**Our ref:** AC/2023/131915/01-L01  
**Your ref:** WW010003

## **CAMBRIDGE WASTE WATER TREATMENT PLANT RELOCATION FLOOD RISK ASSESSMENT**

We have reviewed the revised Flood Risk Assessment (FRA), Application Document Ref. 5.4.20.1 Rev 03, dated December 2023 that was received on the 19 December 2023.

Figure 3.1. Locations of existing and new outfall (drawing 00000-100006-CAMEST-FED-GAR-C-3110)

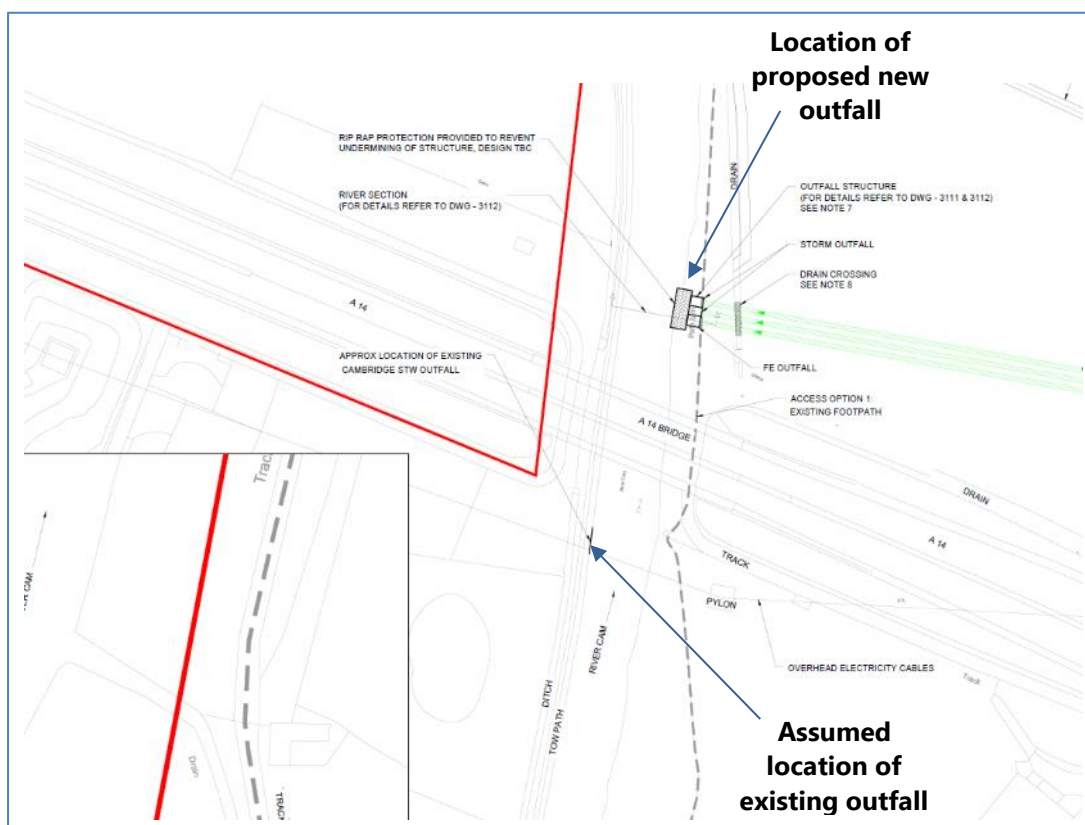
As such, the baseline and post-development model results are not directly comparable. The report also indicates that there will no longer be discharges from the Waterbeach outfall once the new WWTP is in place, but the existing discharges are not represented in the model. As such, the model results are likely to underestimate flood extents and depths in the baseline scenario in the downstream part of the model.

We consider that either another baseline scenario should be run with predicted future growth included or another post-development scenario should be run without planned future growth included. This would allow the baseline and post-development results to be directly compared and would allow the impact of the new WWTP and outfall on local flood risk to be determined. If possible, existing discharges from the Waterbeach outfall should be included in the baseline scenario.

Figure 4.1. Base case – 1 in 100 year plus climate change, 61 hour storm, 30 hour outfall flow offset

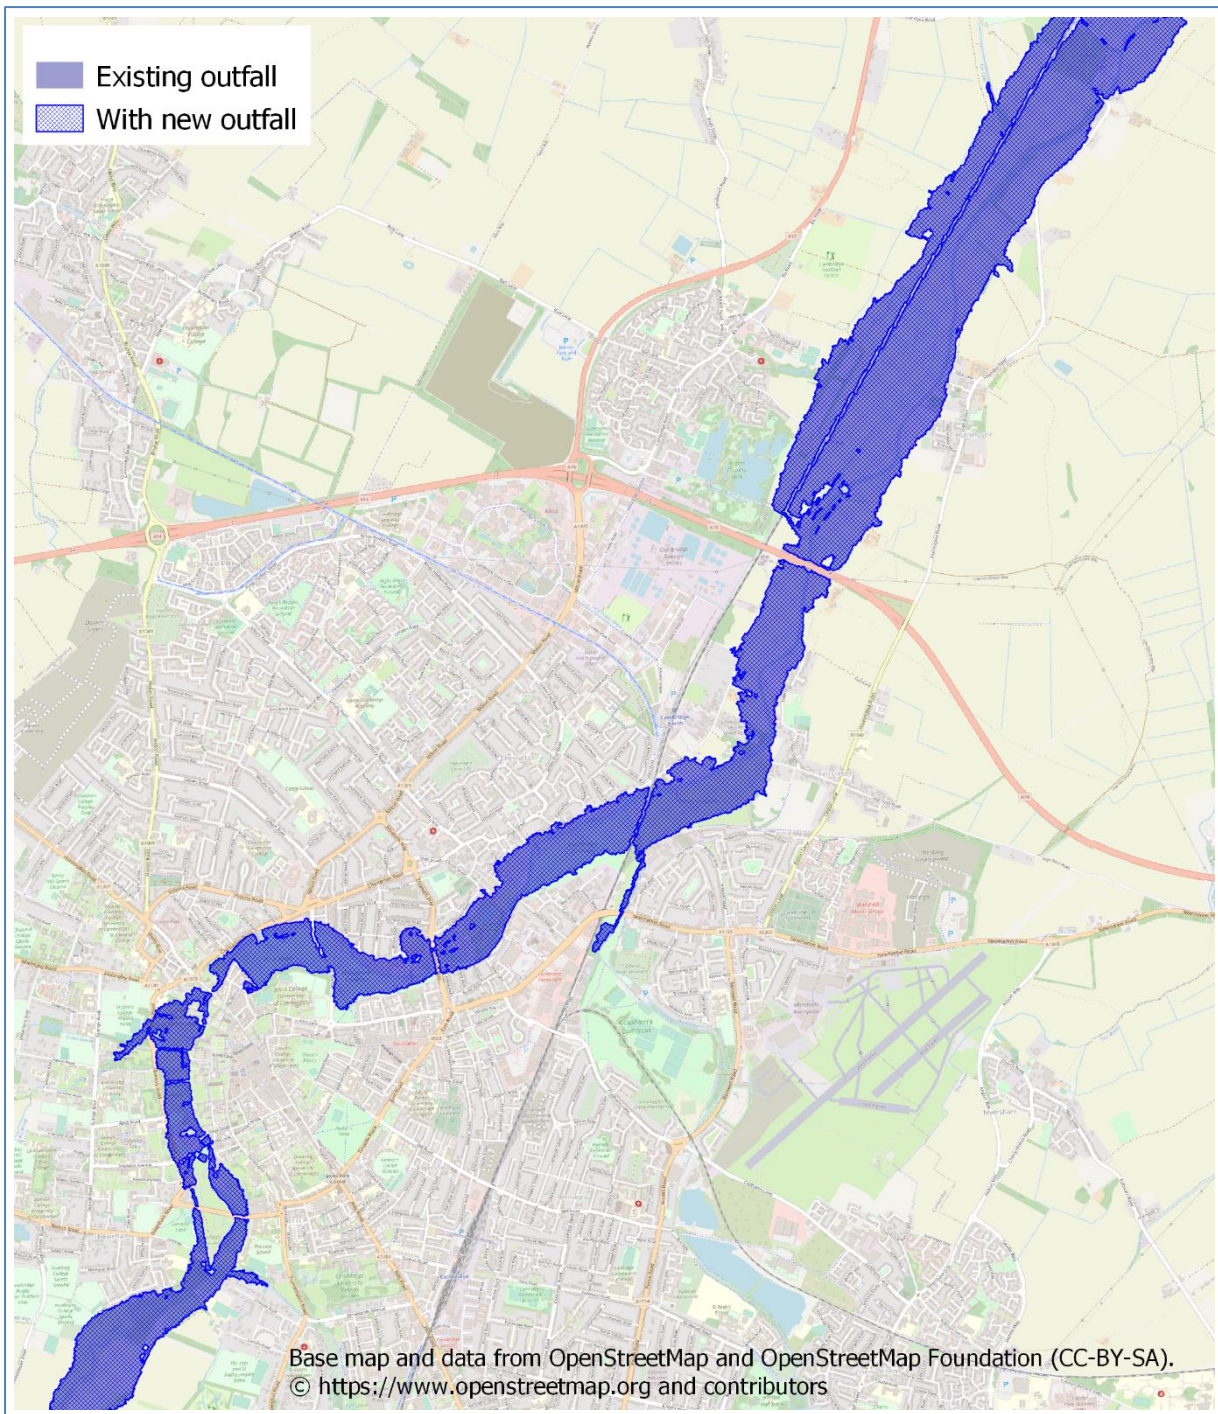
Chapter 4 of the FRA presents the results of fluvial modelling that has been undertaken to assess the impact of the proposed new outfall on flood risk. The results of the modelling indicate that there would be an increase in flood extents and depths in several locations downstream of the new outfall. This includes areas of land where properties are located to the east of Waterbeach.

Drawings that clearly show the impact and locations of any areas of land where an increase in flood depths and/or extents is predicted must be included in an updated FRA. Drawings and plans of any mitigation measures must also be included in an updated FRA.
